Suffolk County Council (20041323)

Comments on the Outline Written Scheme of Investigation

Bramford to Twinstead (EN020002)

17 January 2024

Illustration 2.1 – Communication Chain

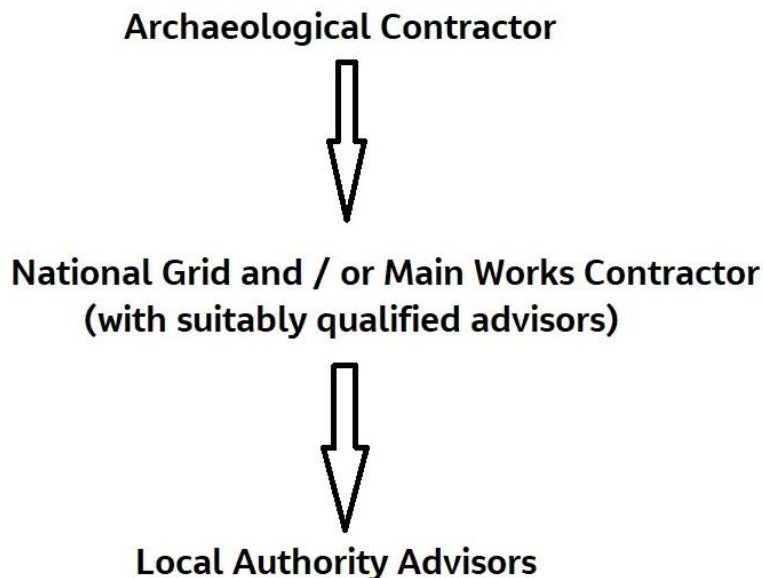
1i	General Considerations - Roles and Responsibilities	2.2.1	<p>National Grid will be responsible for:</p> <ul style="list-style-type: none"> • Appointing a suitably qualified Archaeological Contractor; • For implementing the measures set out in the AFS and the OWSI; • Producing DWSI for the archaeological mitigation work; • Leading any necessary consultation with the local 	<p>Due to the size of the project will National Grid have an Archaeological Clerk of Works appointed to the project?</p> <p>The first bullet point should be the following:</p> <ul style="list-style-type: none"> • Appointing a suitably qualified and experienced* Archaeological Contractor <p>Additional bullet points here that National Grid will be responsible for:</p> <ul style="list-style-type: none"> • Daily communication with the archaeological contractor during archaeological site works.

TITLE: Figure 1
 Proposed Archaeological Mitigation - Key Plan

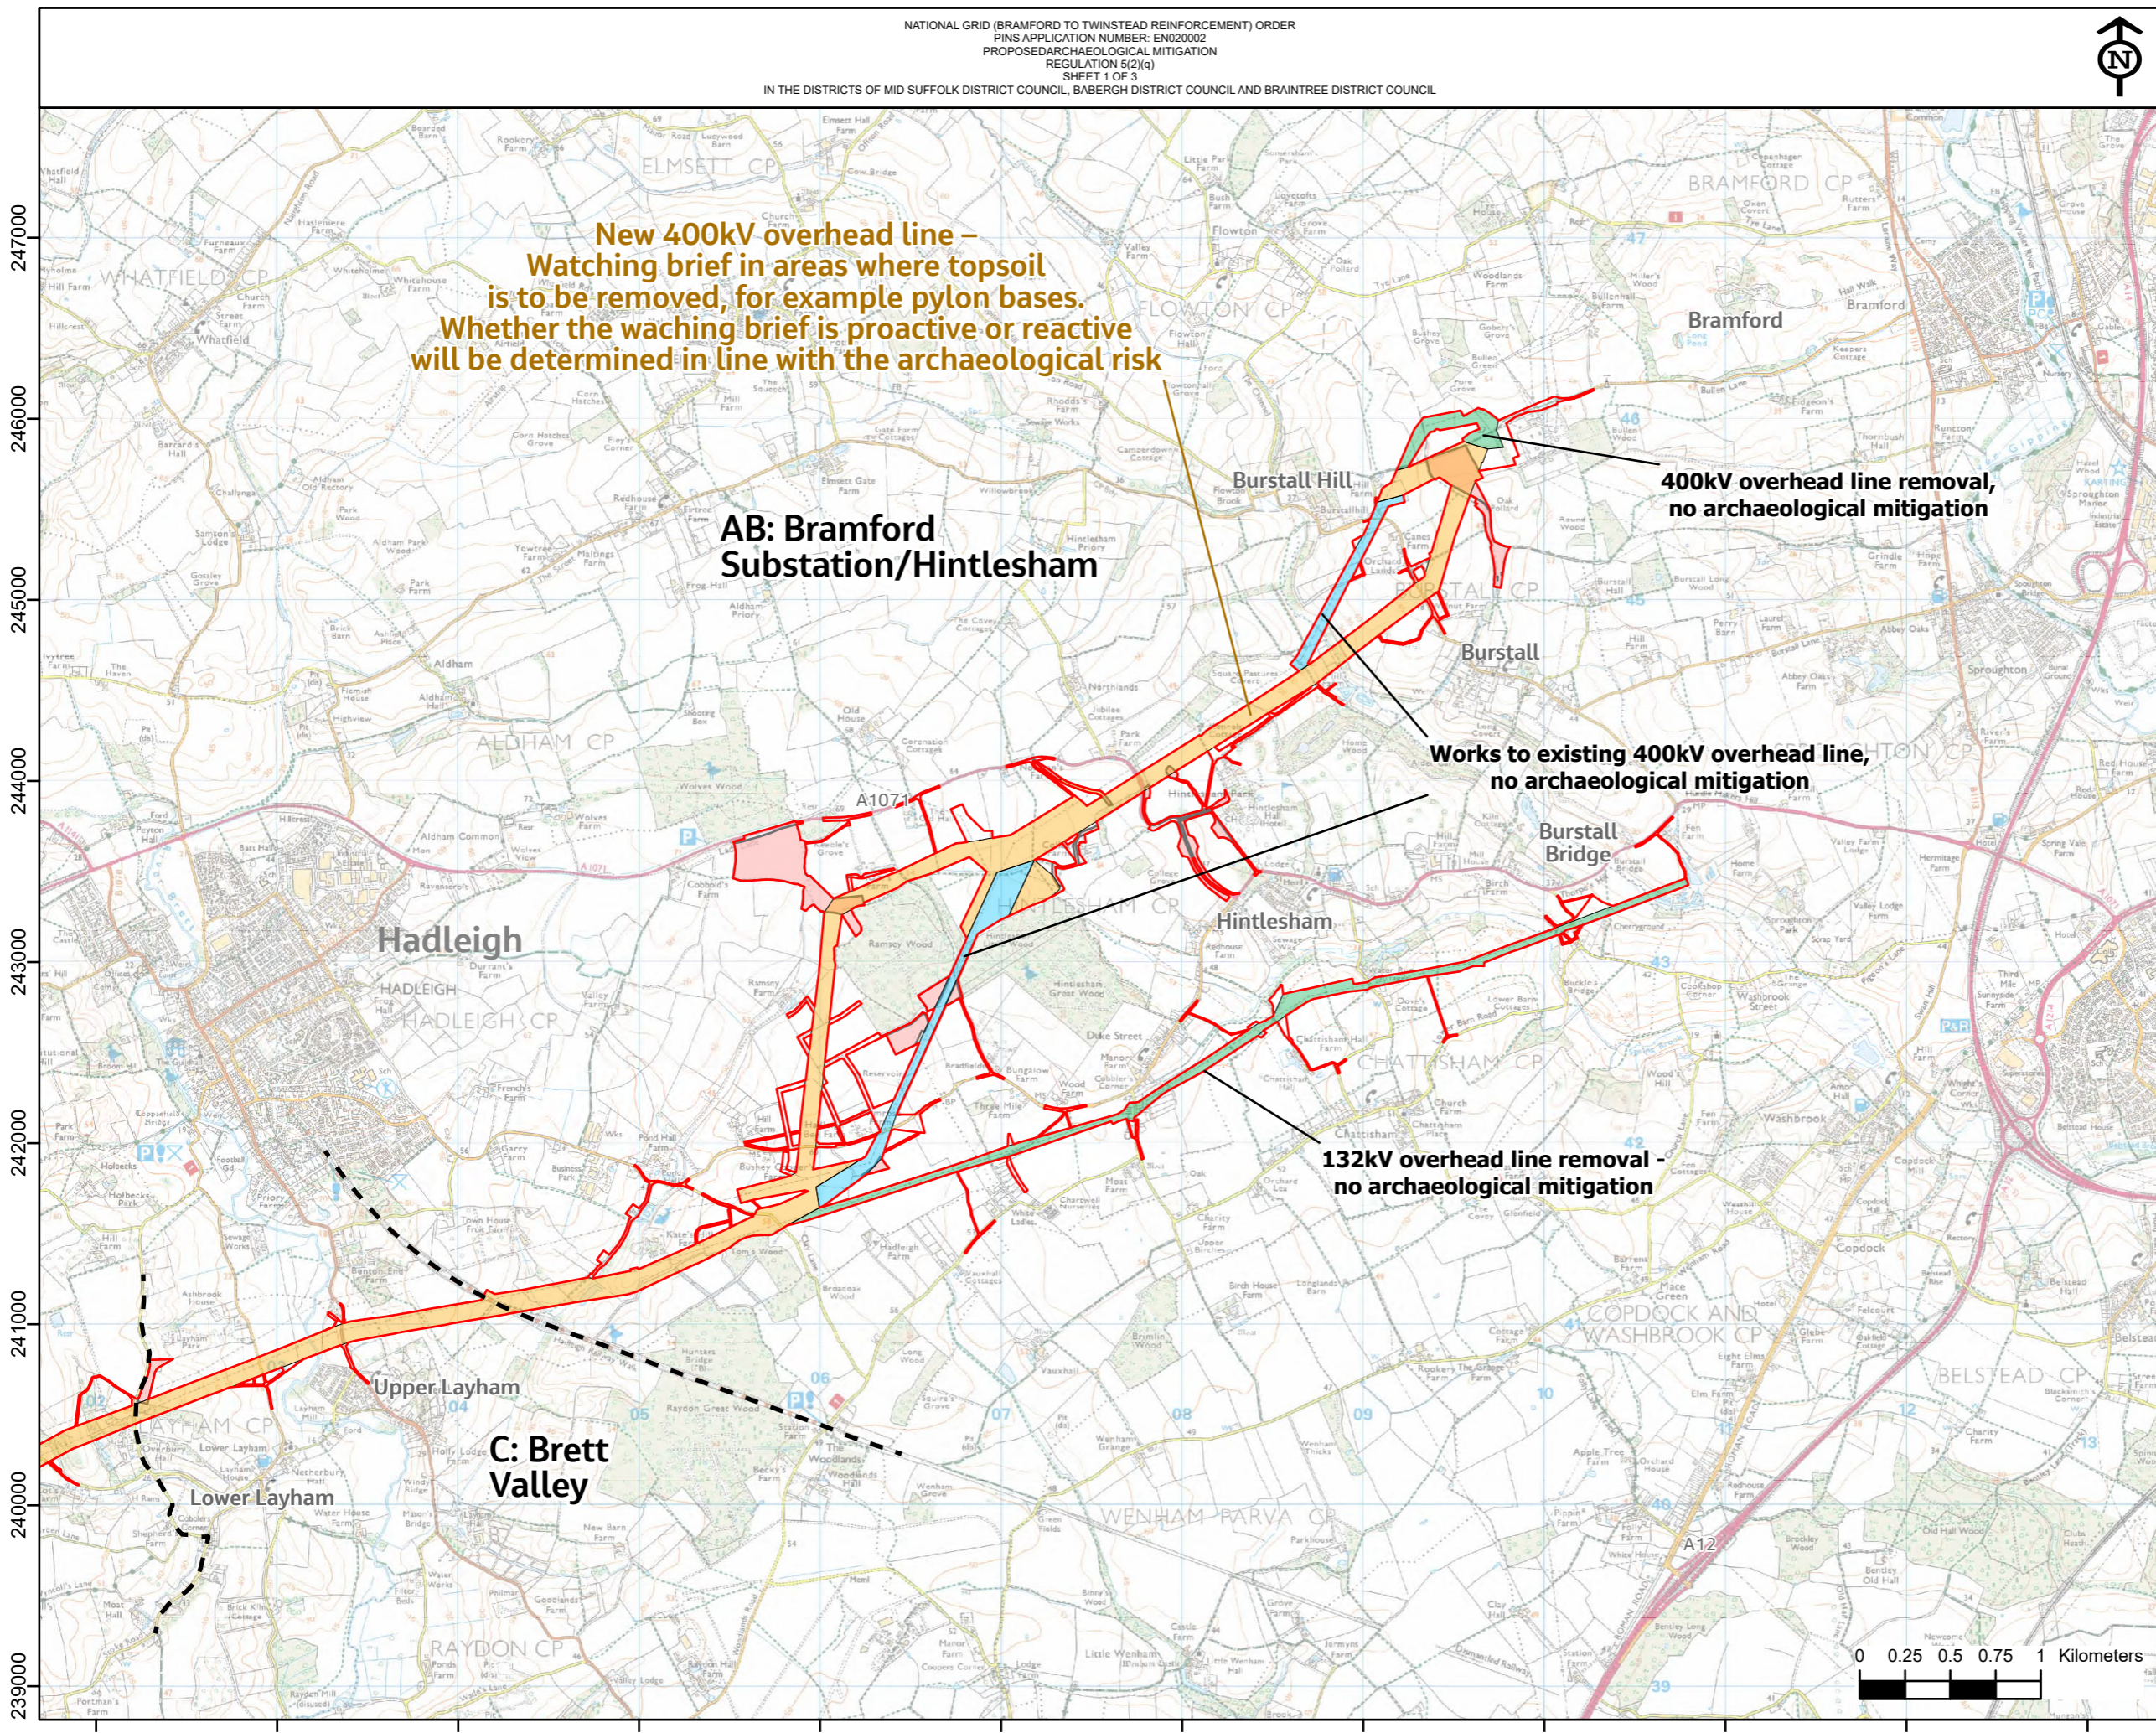
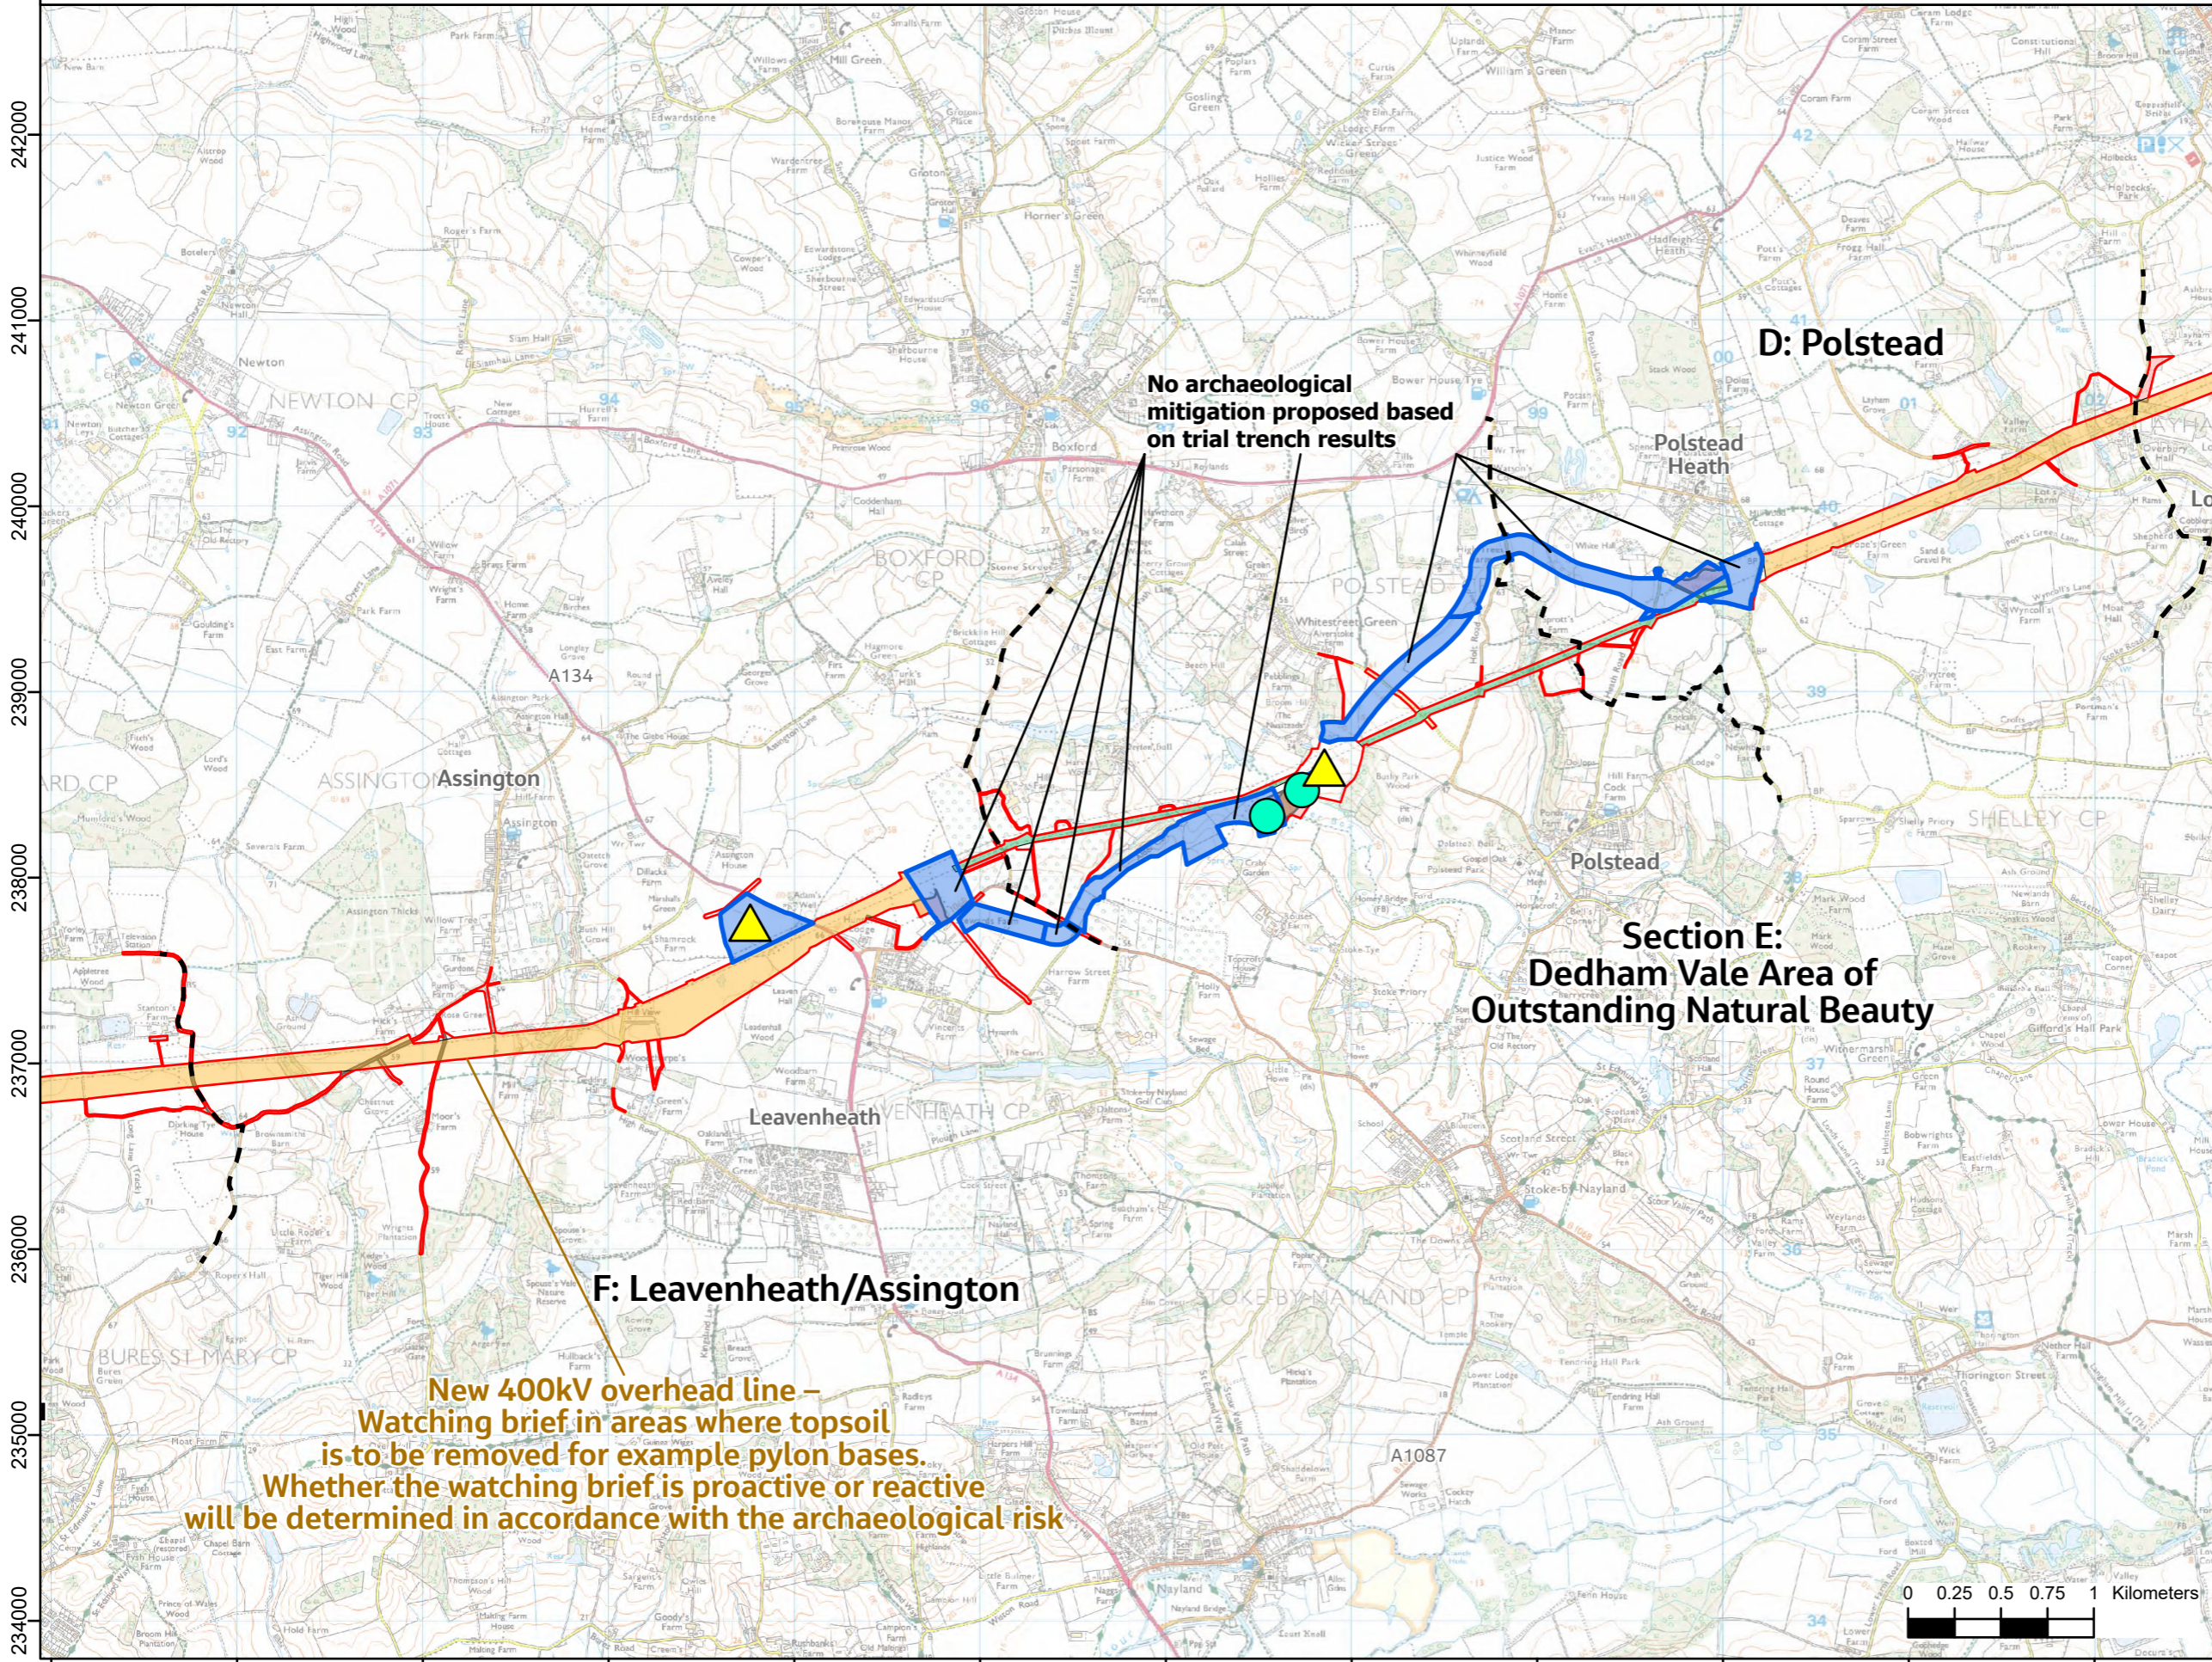
<p>1s</p>	<p>Targeted Archaeological Open Area Excavation – Locations</p>	<p>4.2.1</p>	<p>Currently, targeted Archaeological OAE is proposed in two locations within the Order Limits as shown on Figure 1: Proposed Archaeological Mitigation:</p> <ul style="list-style-type: none"> • Section G: South of Workhouse Green, where evidence from the trenched evaluation indicates an area of Roman activity; and • Section G: Either side of Moat Lane west of Lamarsh, where intensive cropmark activity located in the HER has been tested by trench evaluation and proven to contain Iron Age and Roman archaeology. 	<p>SCCAS have only seen results of the trenched archaeological evaluation for stages 1-4 and have not seen the full results of the fieldwork.</p> <p>See comment for 1.5.1.</p> <p>As there has only been low level of trenched archaeological evaluation within the undergrounding sections of the proposal, at a 2% sample, there is insufficient information to accurately define areas for archaeological mitigation where trenched archaeological evaluation has been undertaken.</p> <p>As a result, there is a need for further trenched archaeological evaluation to be undertaken post-determination for the areas that have not been trenched and in the areas that have been subject to pre-application trenched archaeological evaluation so the archaeological resource can be accurately quantified.</p> <p>The OWSI should therefore be a process document and should not contain details of defined areas for archaeological mitigation. Instead, the OWSI should state that there will be archaeological mitigation required to be undertaken prior to the construction phase, which would be defined in Detailed Written Schemes of Investigation (DWSI). Areas for archaeological mitigation by OAE should include:</p> <ul style="list-style-type: none"> • Area G1 – an initial 40mx40m excavation area around two probable Late Bronze Age – Early Iron Age cremation burial which could be part of a cremation cemetery in and around Trench G1.49. there may be a requirement to extend the excavation area further depending on the archaeology present. It is not uncommon for cremations of this period to be focused around or in the vicinity of earlier burials/funerary

1x	Archaeological Strip, Map and Sample - Locations	5.2.1	<p>SMS will be applied in areas of the project where the presence of archaeological remains warrant preservation by record and the project is anticipated to require topsoil removal. Areas identified for SMS are shown on Figure 1: Proposed Archaeological Mitigation and include: National Grid December 2023 Bramford to Twinstead</p>	<p>Same as comments as for 4.2.1.</p>
